Department of Planning & Environment – comments on RTS, SSD 7421, 20 Hearne Street, Mortdale, 15 February 2017

I am writing to you in relation to the proposed expansion of the Hearne St Mortdale Resource Recovery Facility (SSD 7421) located at 20 Hearne St, Mortdale ("the Premises"), from 30,000 tpa to 300,000 tpa. It is also proposed to permit waste movements in and out of the facility 24 hours per day. The EPA notes that Mortdale Recycling Pty Ltd hold environment protection licence no. 20622 for scheduled activities at the Premises.

**Response To Submissions Report
 Mortdale Resource Recovery Facility (SSD 7421)
 20 Hearne Street Mortdale**

Figure 7

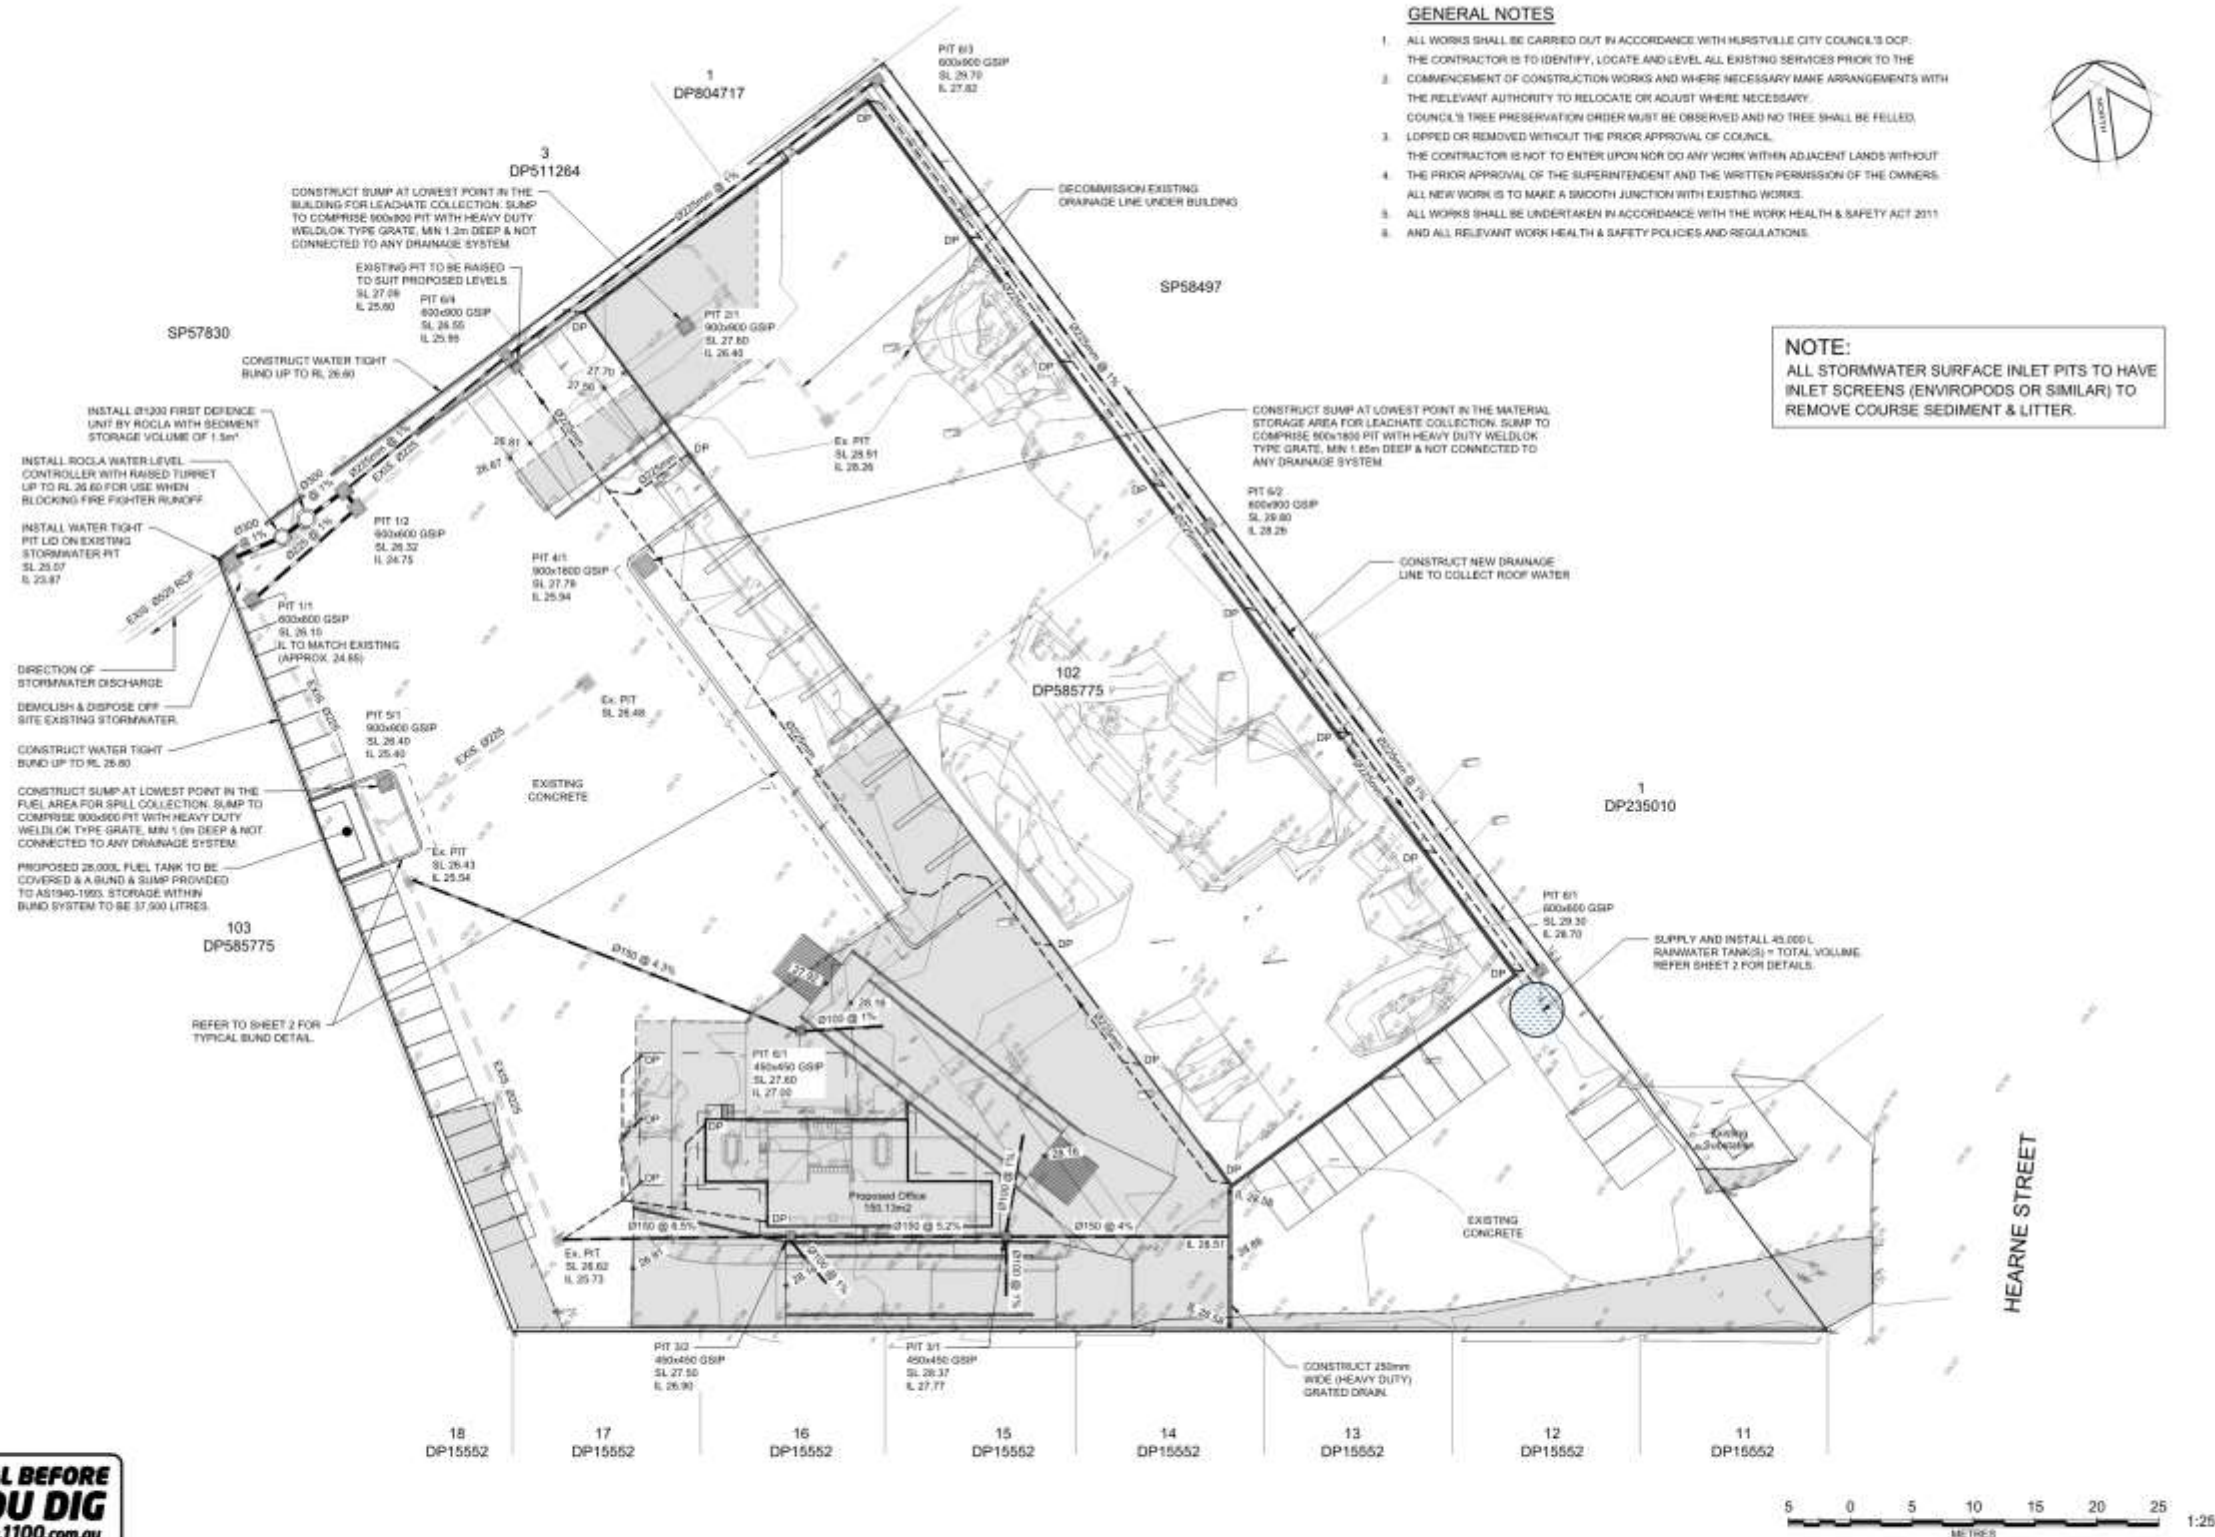
- (b) Given the information provided within Figure 7 of the RTS, the proponent has clearly indicated that the proposed shed and awning will be appropriately sprinkler protected, which is supported by FRNSW.

However, FRNSW has also reviewed the basic details provided within Figure 7 which relate to the fire hydrant system and do not support the locations indicated on the drawing for both the hydrant booster assembly and attack fire hydrants. Details relating to the sprinkler booster assembly, or any associated dedicated firewater storage tanks have not been provided in Figure 7 of the RTS.

Figure 5 | Location of Stacking Spaces

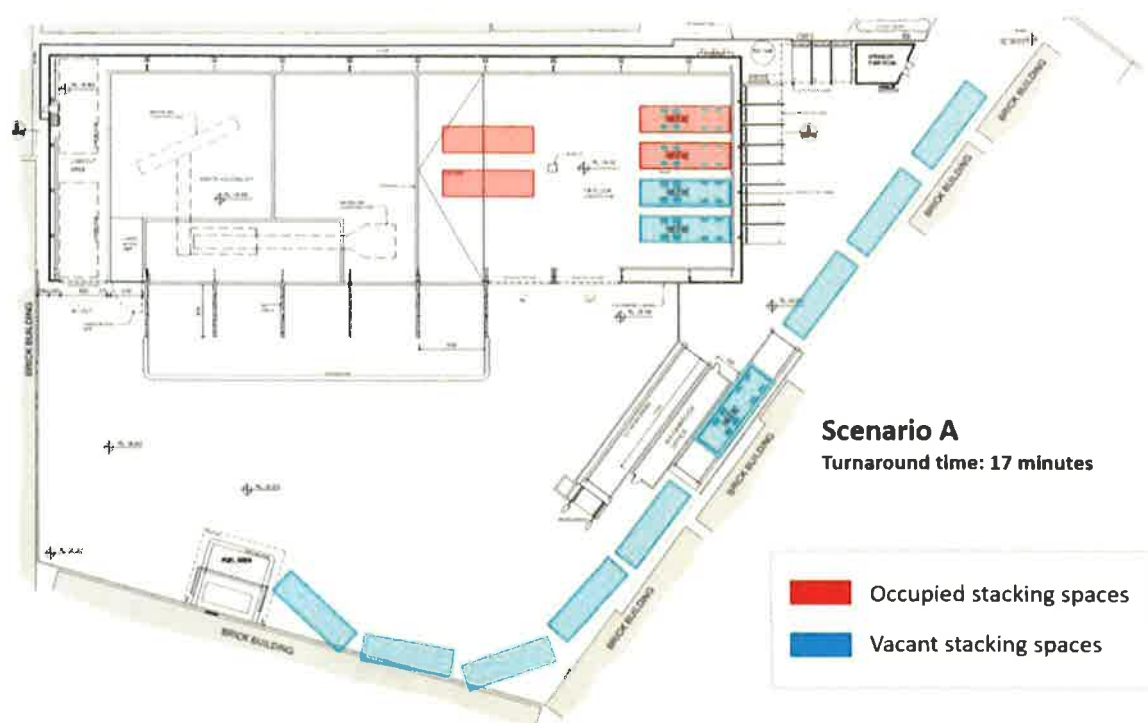
4	Exiting trucks have been placed in a location which contradicts the stacking plan diagrams (see below). This requires amendment.

The vehicle stacking plan "Response to Submissions Letter – Traffic Vehicle Movements" Attachment C) conflicts with many of the provided swept path arrangements for 19m vehicles indicated in ("Response to Submissions Letter – Traffic Vehicle Movements," Attachment G). The introduction of semi-trailers/truck and dog vehicles into the site has the potential to impact on the timing of queueing arrangements within the site which may increase the assumed vehicle processing turnover time of 25 minutes (as indicated on page 7). Any potential conflict between queueing and turning vehicles that leads to vehicle queueing on Hearn (or surrounding) streets is not supported.
